**Planning Application Ref:** WA/95/18/RES

**Location:** Land east of Tye Lane, Walberton

**Description of works:** Approval of reserved matters following outline consent WA/44/17/OUT for the erection of 175 No. dwellings, car parking including garages, internal access roads, footpaths, parking & circulation areas, hard & soft landscaping, allotments, play areas/equipment & community orchard & other associated infrastructure & engineering works. This application may affect the character & appearance of the Walberton Village Conservation Area

Tree Survey & Constraints with Shading

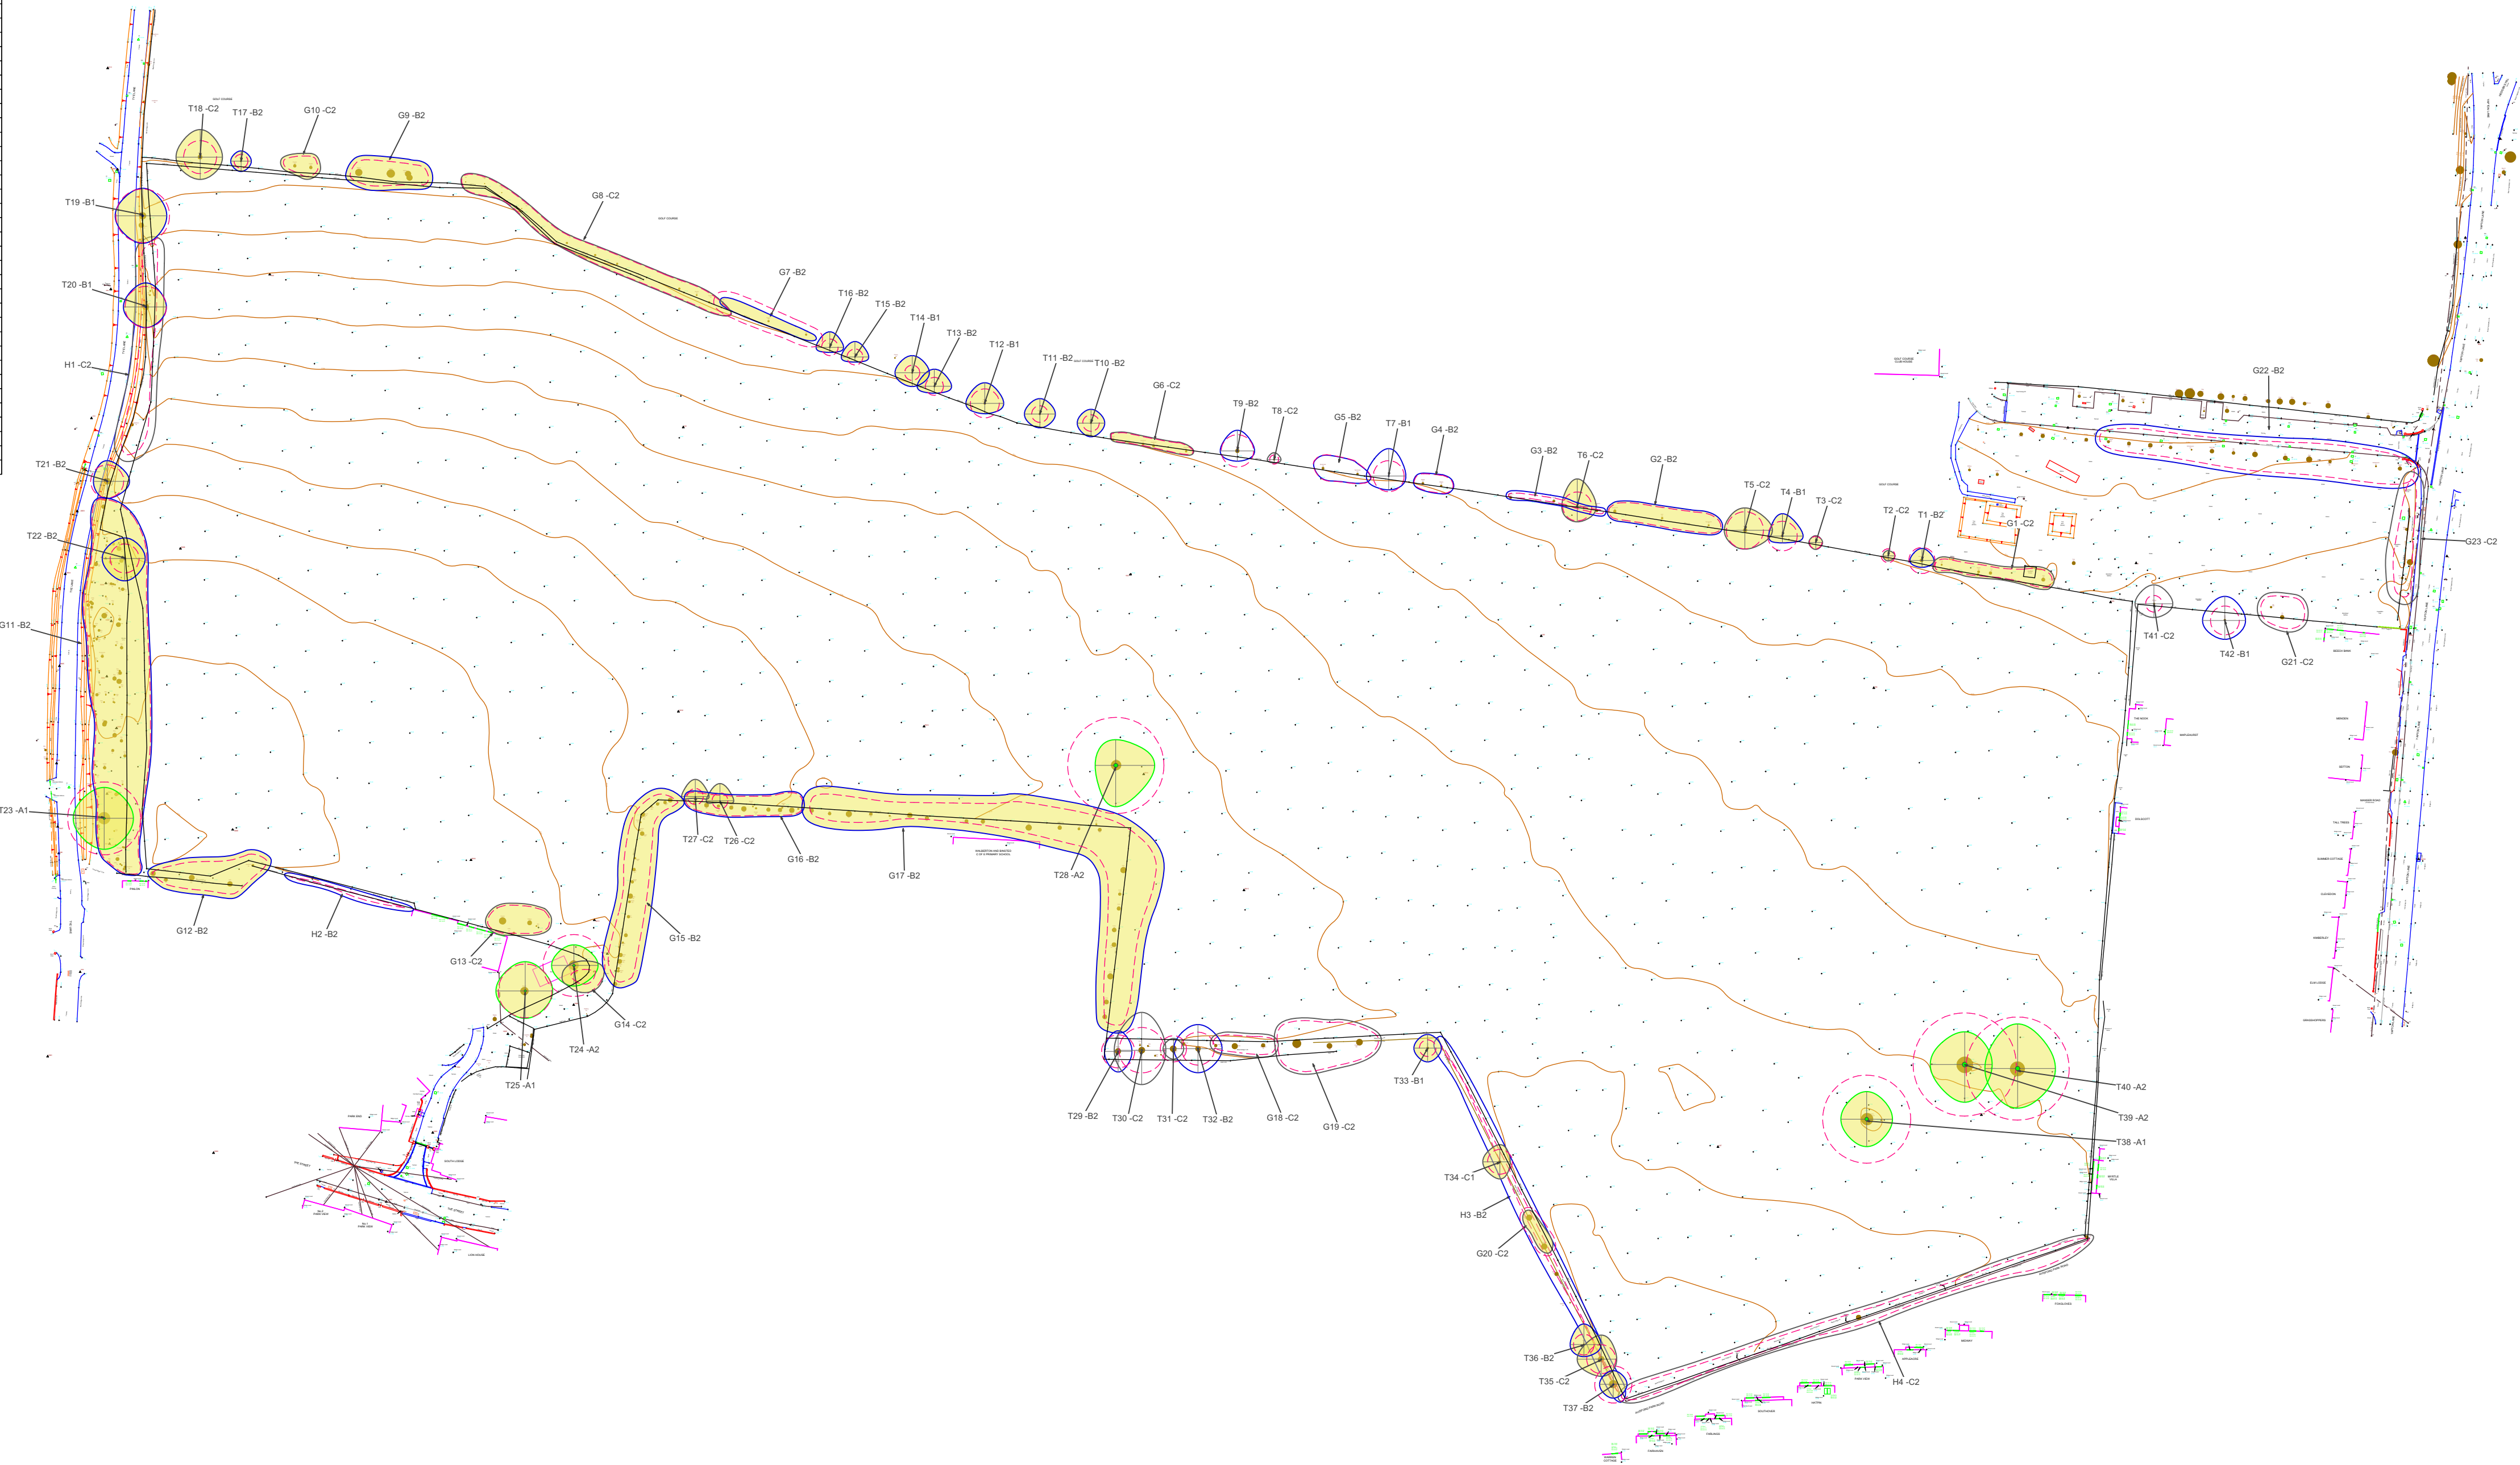
- The applicant has employed Barton Hyett - Arboricultural Consultants, who have submitted a revised Arboricultural Survey, Impact Assessment and Protection Plan to accompany this application. Tree Survey data is comprehensive and accords with the requirements of BS5837:2012.
- Having studied the Protection Plan, there is an assumption that RPA incursion in the north-east corner of T28 persists despite repeated requests (and verbal agreement) from/to the applicant to design-out conflict with this under-pressure tree.
- Various landscape plans show footways outside of RPA's for T38-T40, which is a welcome revision. That said, there is no one defining plan that makes it clear to me which is the ultimate design around these dominant oak trees.

- The original objection must be sustained as the applicant does not appear to have fully addressed long-established concerns. RPA incursion from carriageway/driveway construction appears to persist at T28. This is unacceptable to me in isolation but especially so as the tree is going to be the recipient of cumulative (potential) stress events - namely the significant crown reduction pruning to bring it to an appropriate state for residential area, subterranean thrust-boring to install new pipework, construction tight to the west edge of the RPA and the aforementioned vehicle access.

- We have not yet had site of a detailed arboricultural method statement and tree protection plan which provides details of and demonstrates how the few significant trees deep within the site (T28, T38-T40) are to be adequately respected and protected.

- As it stands I must register an **OBJECTION**, until such time as I have sight of a definitive **site layout plan** which clearly shows the following; tree root protection areas, details of all RPA incursions (e.g. footpath, carriageway, pipework run), together with an associated **tree protection plan** showing any areas of 'No-dig' construction and a supporting **method statement (AMS)** which explicitly describes all the measures to be taken to ensure those trees are adequately respected and protected.
- I am able to remove my objection and can recommend **APPROVAL** for this scheme, subject to the following conditions being applied:
